Engineers Comments Regarding Surface Water Drainage

Application Reference:	A/177/25/DOC	Reviewer Reference:	ADC/KW/SB
Planning Officer:	Kathryn Welch	Date of Review:	15/12/2025
Site Name:	Rustington Golf Centre, Golfers Lane		
Application Description:	Approval of details reserved by condition imposed under A/163/24/PL relating to conditions 6-surface water drainage scheme and 7-maintenance and management of surface water drainage system.		
Assessment Number:	1 of 1

SECTION THROUGH RETENTION TANK 2

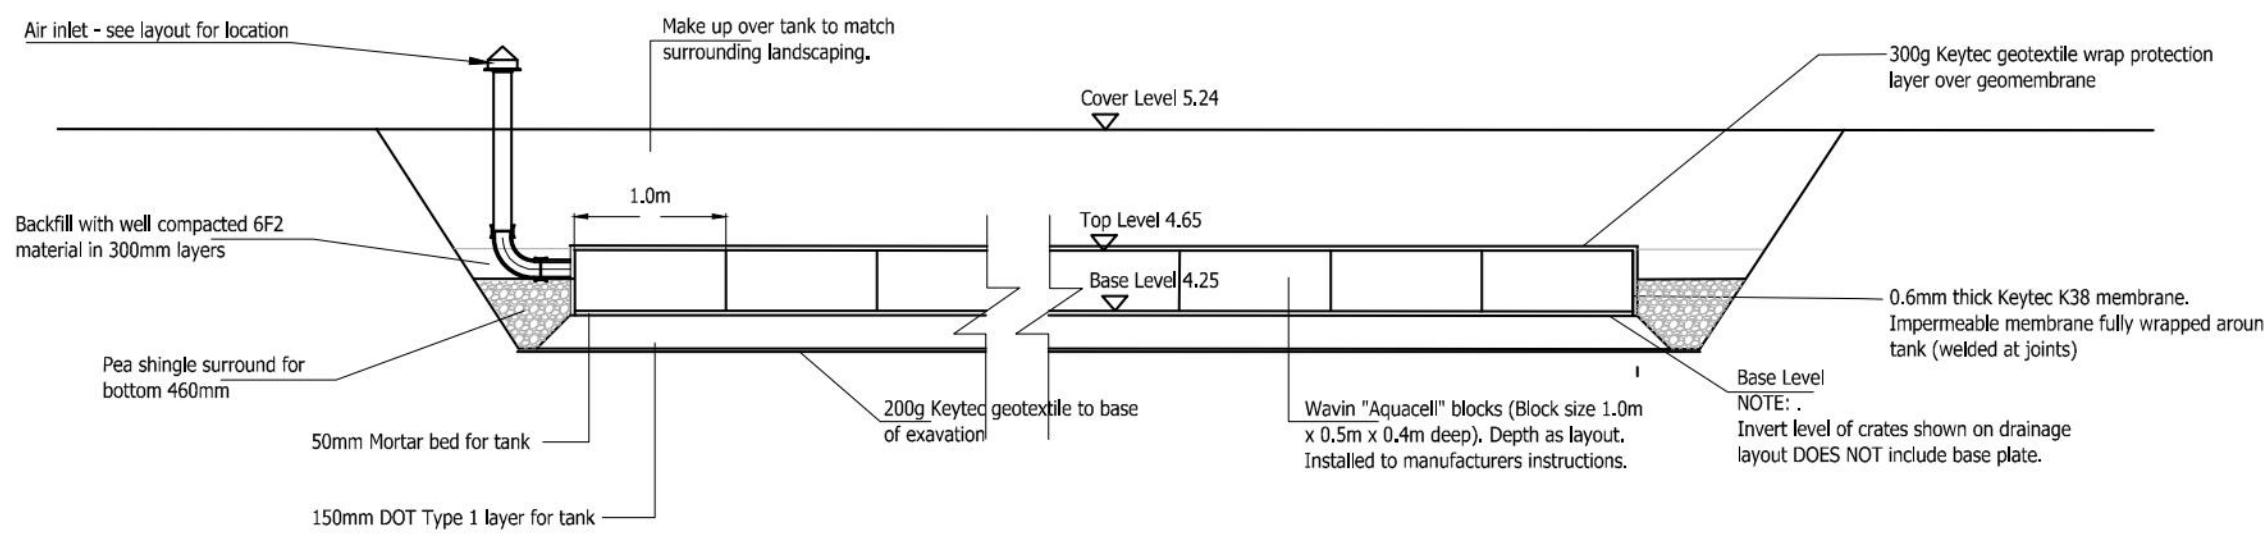
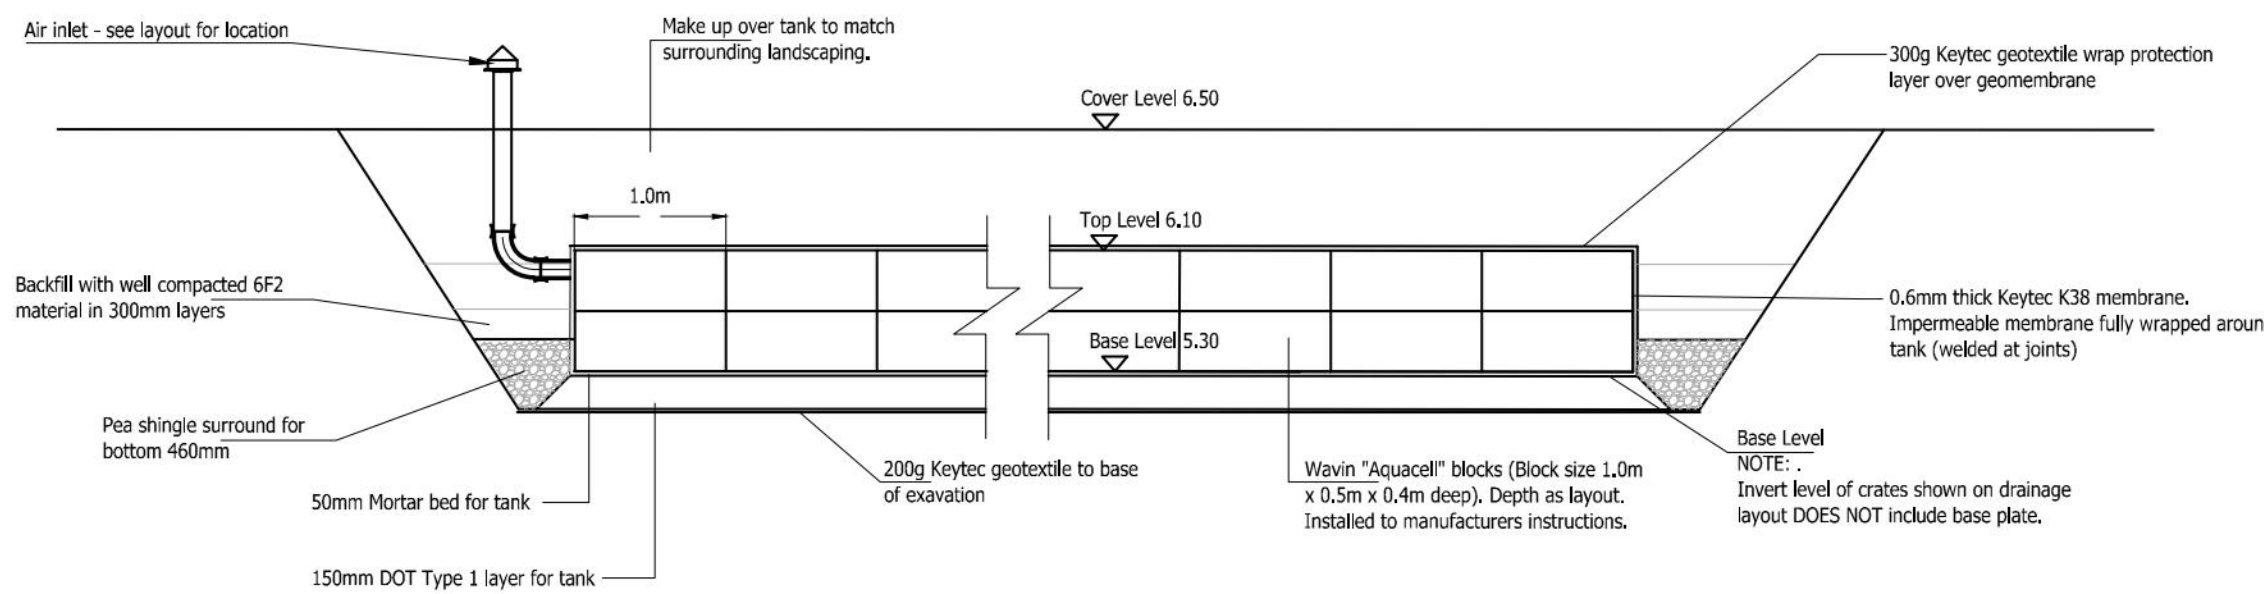
9.	Please provide Interception assessment which demonstrates compliance with the NSFS. Comments para 3.9 are noted, however, these do not constitute a full assessment. Should 1m of unsaturated ground between the base of the tank and groundwater levels be proven, you may wish to consider if the tanks need to be impermeable lined. A permeable liner may be used to allow for infiltration for interception purposes. Further information regarding interception at Interception drainage Arun District Council

TYPICAL SWALE DETAIL

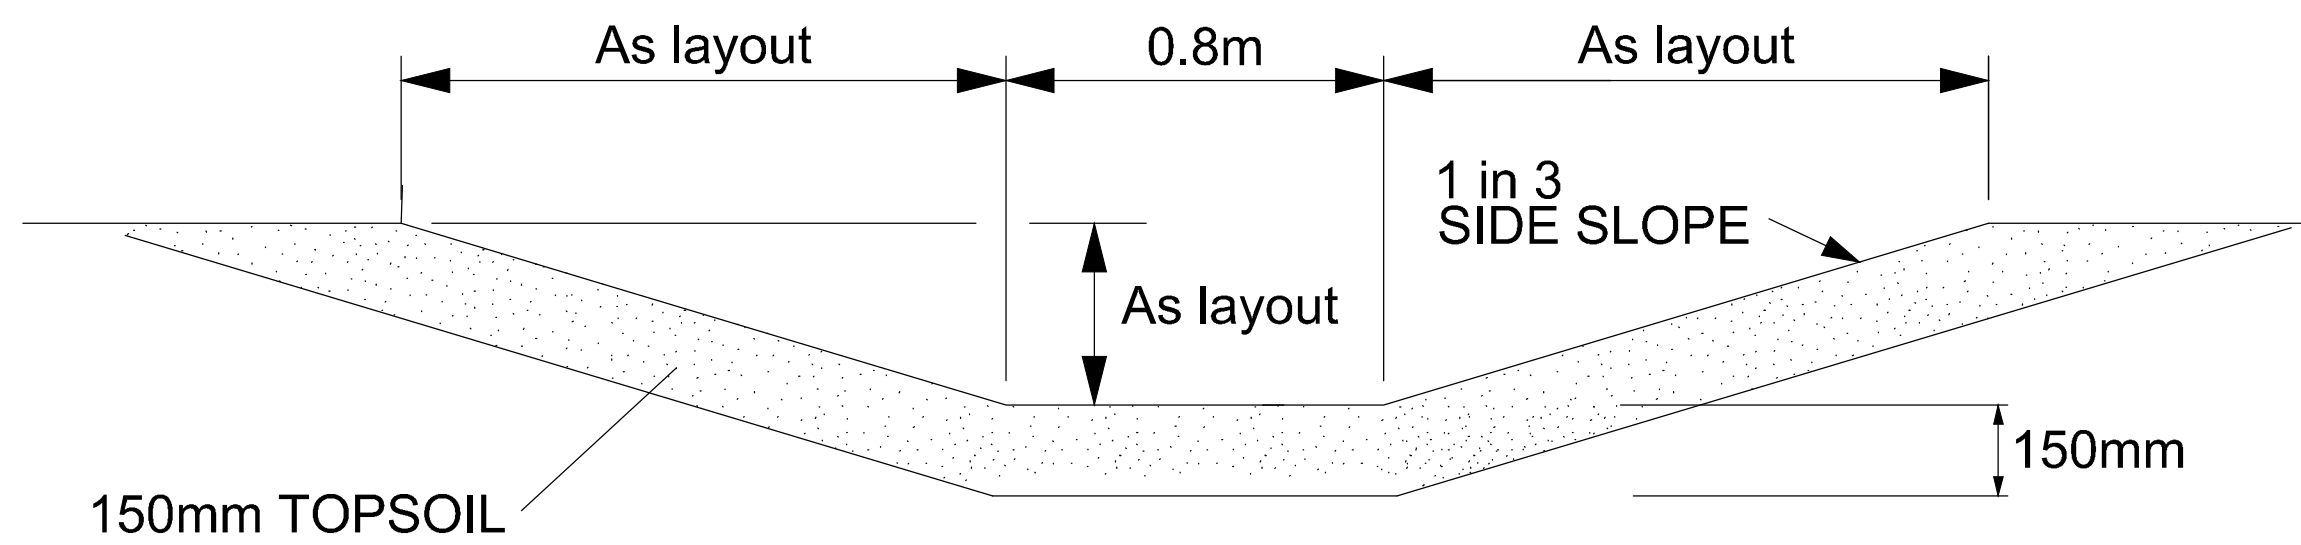
16.	It appears that the swale is immediately adjacent to a group of trees. Please clearly demonstrate on plan the root protection areas of these trees and measures to protect drainage features

from root damage. (If the swale needs to be lined to prevent groundwater ingress – if there is less than 1m of unsaturated ground between the base of the swale and the peak groundwater level.)
